CITY OF ALBUQUERQUE

April 26, 2005

**Re: PNM Data Center, 2401 Aztec Rd NE, Traffic Circulation Layout
Architect's Stamp dated 4-20-05 (G16-D8C)**

SHEET C-3

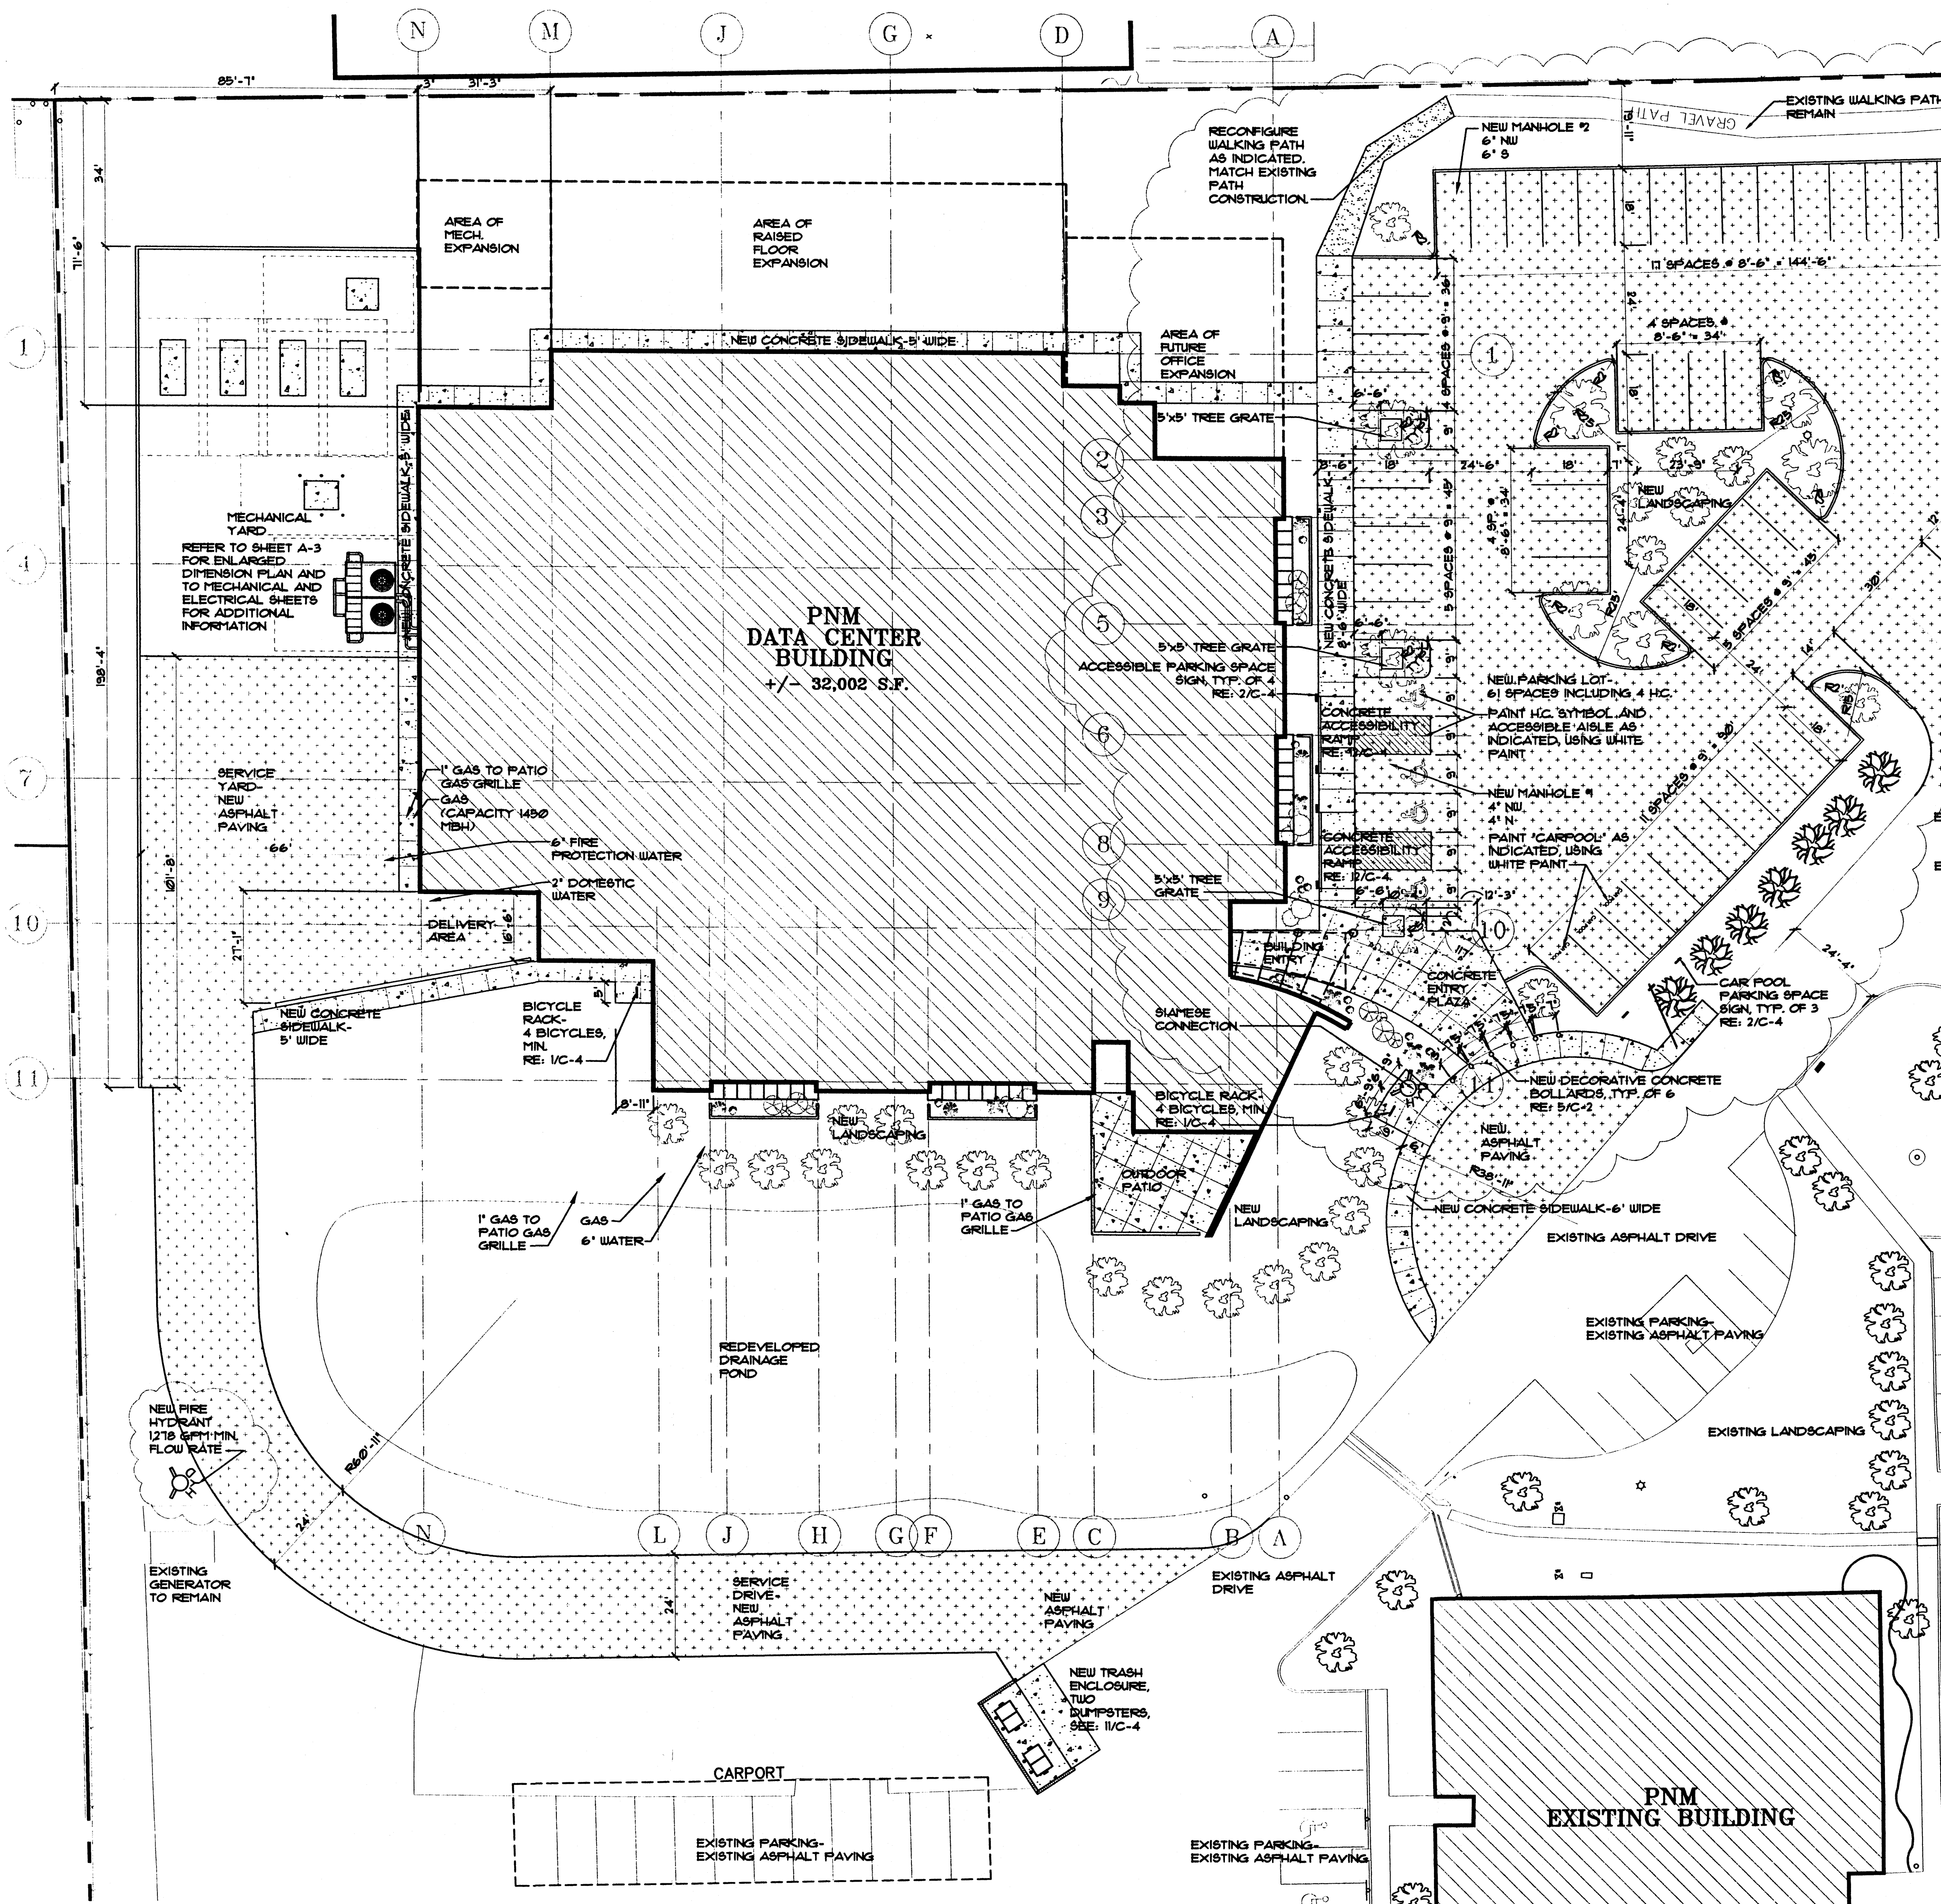
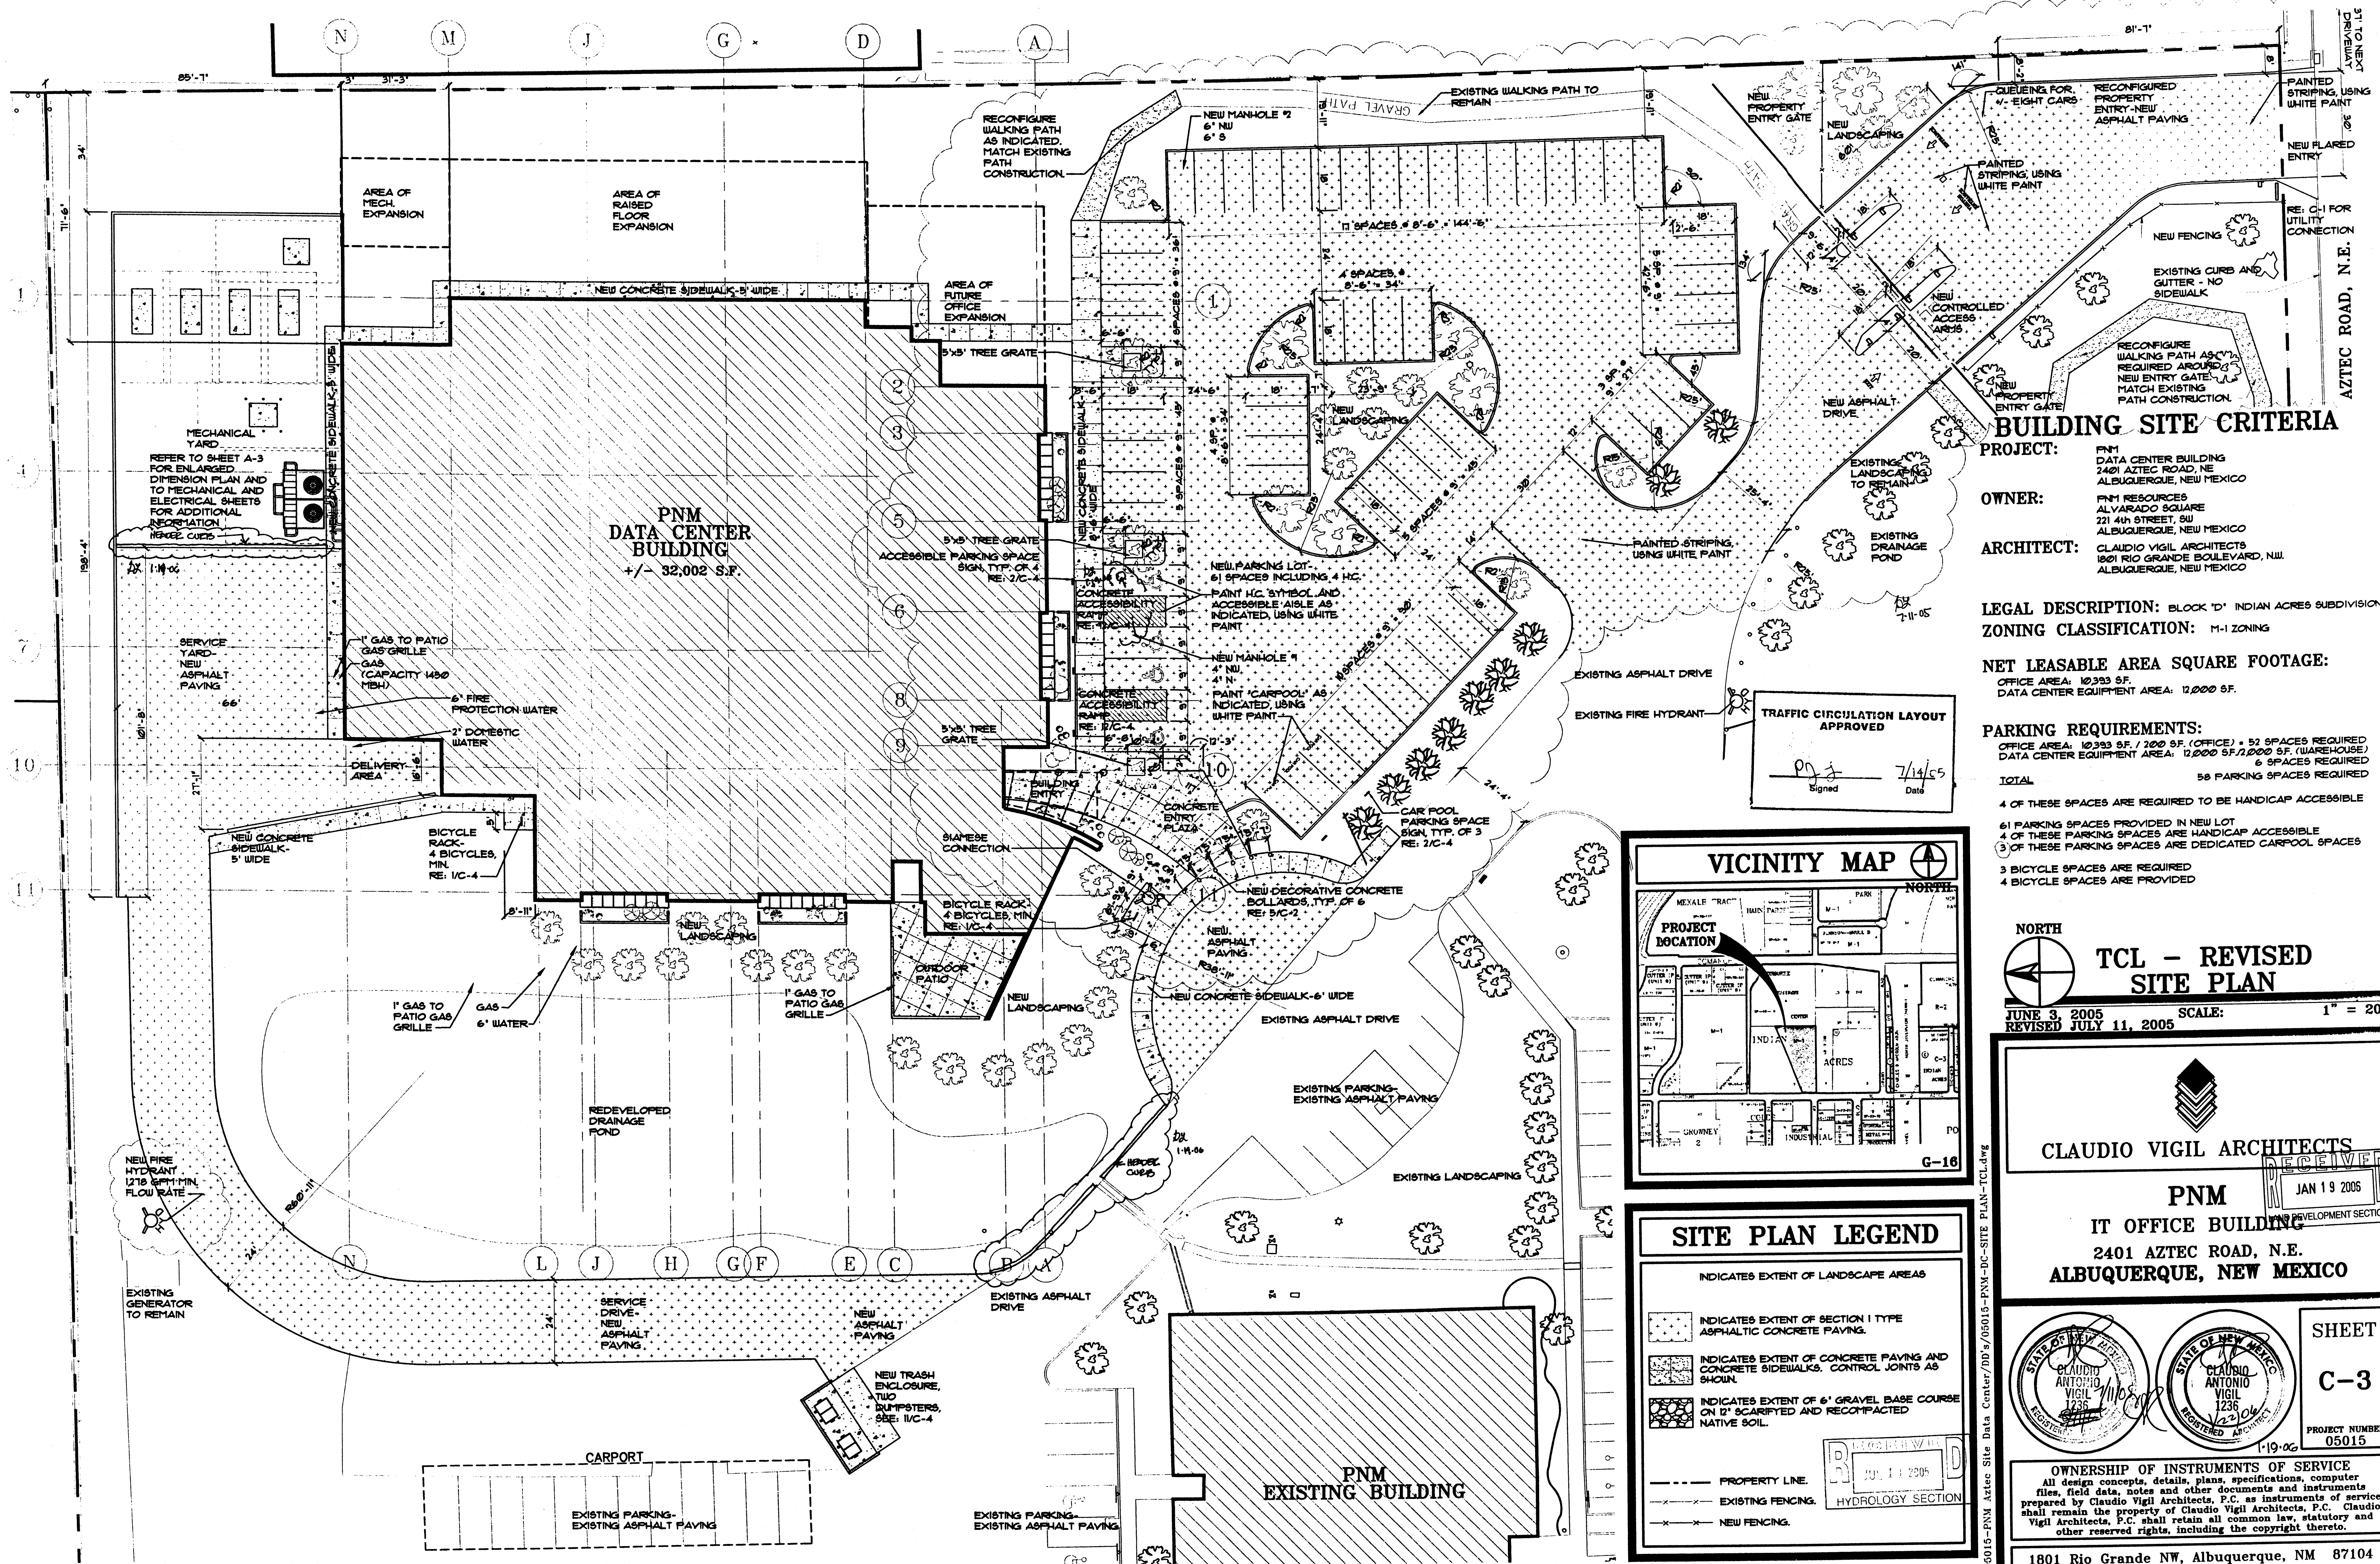
1. Label Aztec Street and provide details, such as the location and dimensions of any sidewalk, the width of the existing entrance, and the location of the nearest drivepad on the adjacent lot.
2. Compact vehicle parking spaces have a minimum width of 8 feet.

Aztec St - provide info - SW width, etc.

← Dimension of Driveway
at entrance

8' length for Compact parking
space
